# KITTTITAS COUNTY COMMUNITY DEVELOPMENT SERVICES

## RE: NOTICE OF DECISION – Clarke & Chellis #2 Variance (V-08-03)

**To:** Trudie Pettit, Staff Planner  
**From:** Michelle Geiger, Plans Examiner Kittitas County Community Development Services  
**Date:** April 2, 2008  
**Re:** Clarke & Chellis #2 Variance (V-08-03)

KARI CREEK SHORT PLAT

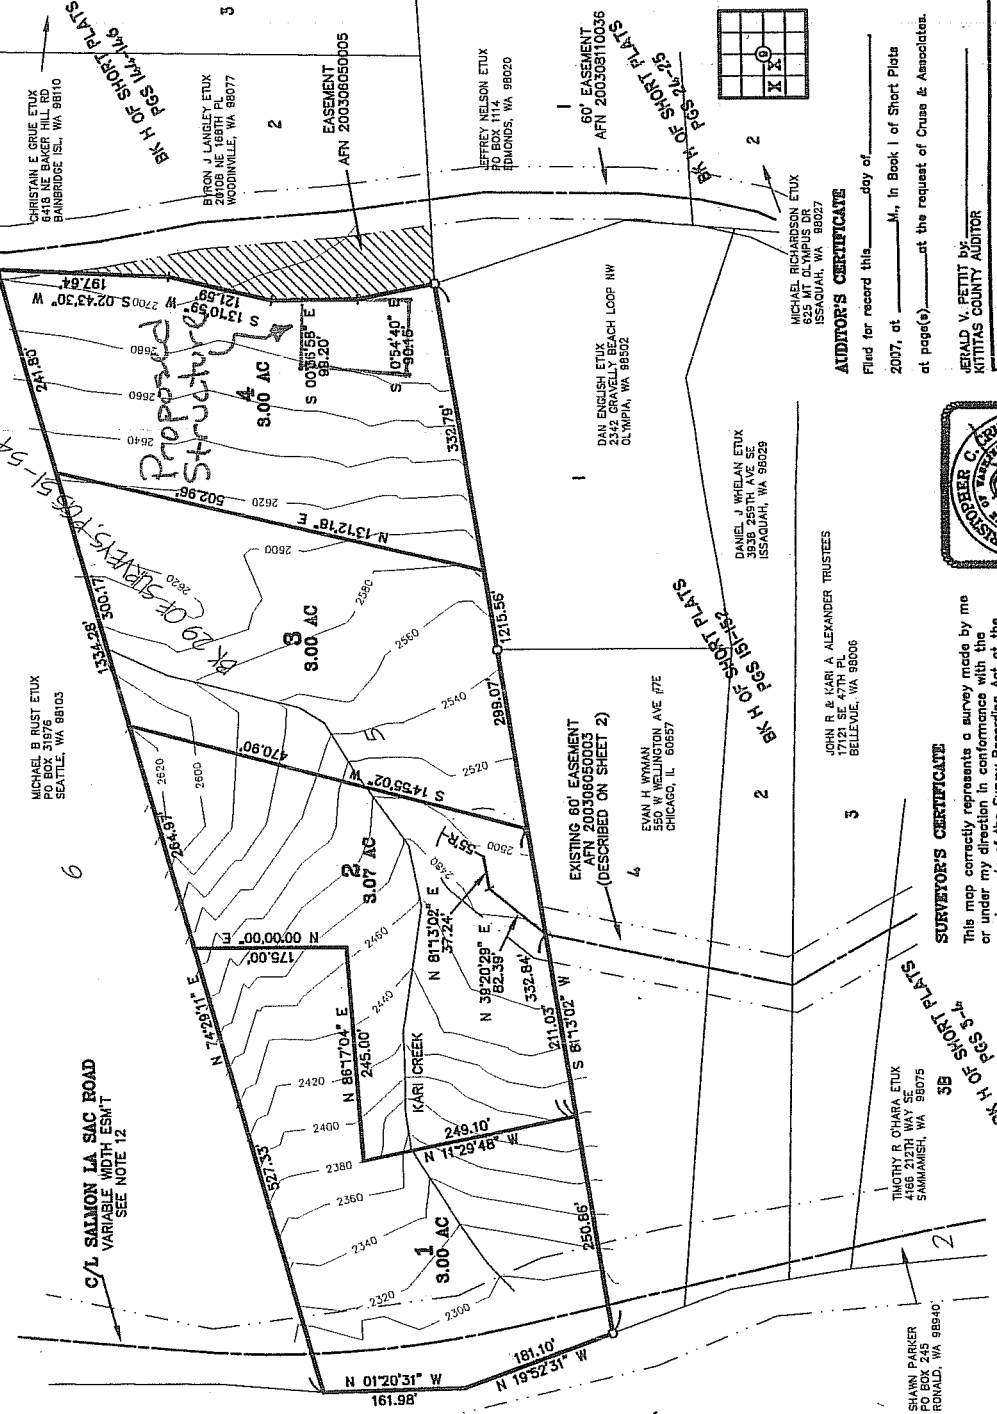
The property listed is outside of a fire district and therefore falls under the requirements of the 2006 International Wild-land Urban Interface Code. Section 603.2 Fuel Modification, requires that defensible space be provided for the structure. The minimum defensible space required is 30' with a range extending to 150' based on site analysis of the property's specific fire hazard severity, as defined in the 2006 IWUIC. A site visit would be required in order to provide actual requirements of construction and defensible space prior to application for building permit. Based off historical data of the area and pending a site visit, there is reason to believe that a structure placed in the manner that has been proposed may not be permitted per the 2006 IWUIC section 503.

1. The house will be up against an existing 60-ft Ingress, Egress and Utility Easement that serves many lots in the Morgan Creek area.
2. At any time, the existing road and/or new utilities could be relocated and/or new utilities or road added up against the west edge of the easement nearest the proposed house.
3. The applicant and/or any future lot owner's need to understand that they do not have any right to contest any existing or new road or utilities within this existing easement area.

If the County grants this variance, it will be an injustice to the setback requirements already established. We purchased this property based on the current setback requirements established by Kittitas County for a Rural-3 zone. Approval of this variance would be a detriment to neighborhood and the value our 3-acre adjoining property. The proposed house would sit directly on our property line (per exhibit 1&2) and their front yard would cross over into our property.
